## DECISION DELEGATED TO HEAD OF PLANNING

**Application No:** H16-1111-22      **Applicant:** Mrs F T Mir Javadi  
**Proposal:** Change of use from residential dwelling to HMO  
**Location:** 106 Halmer Gate Spalding  
**Terminal Date:** 11th January 2023

HMO AT 106 VALMER GATE
SPALDING FOR
MRS F + MR JAVADI

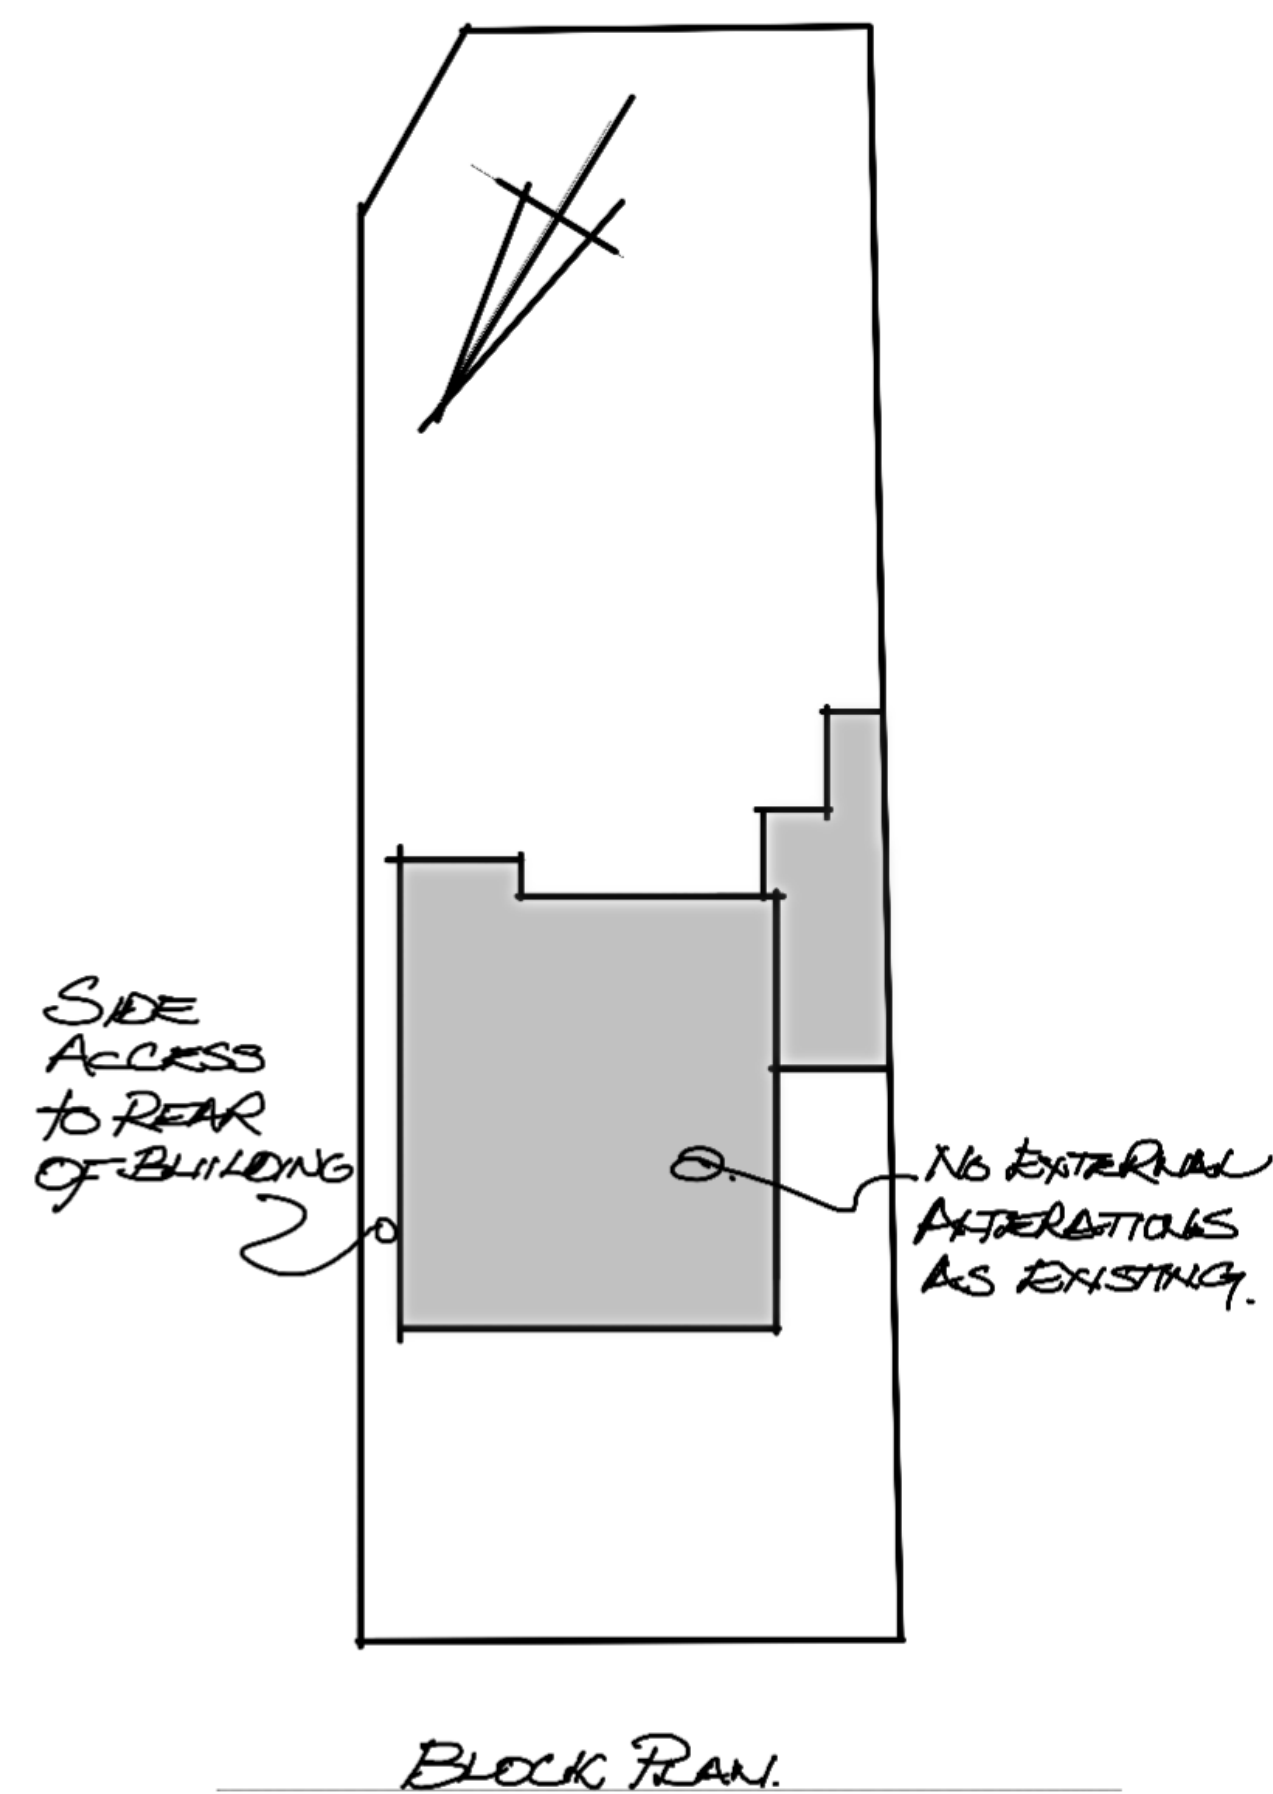
1. The property, whilst the size of a family dwelling, is not in a high density street of terraced / semi-detached properties.
2. The supporting Design and Access Statement indicates that the property would be adapted to accommodate 9 bedrooms. This is an increase of 3 bedrooms on existing (6 existing bedrooms specified on application form). It is considered that increasing the number of occupants in the property will lead to a rise in noise and general disturbance by virtue of an increase in the number of persons residing in the property and associated vehicle movements, coupled with limited internal amenity space. Consequently, the proposal is not considered to satisfactorily accord with this criterion.

7. The bedroom sizes are not considered acceptable. All of the ground floor bedrooms can only be for a single bedspace and, to the first floor, there are two bedrooms which do not comply with the Nationally Described Space Standard (2015), with only one room to the first floor which is sufficient

as a double room. There is no communal living room and only one kitchen and dining room for 9 bedrooms. This will not be conducive to well-being and will likely lead to outdoor gathering, which could have a consequent amenity impact on neighbouring properties. Therefore, the proposal is not considered to accord with this criterion.

The alterations comprise of converting the existing living room into two separate bedrooms, the existing dining room will be converted into another bedroom, creating a new rear entrance. A new window will be formed to the south east elevation on the ground floor, for one of the proposed bedrooms.
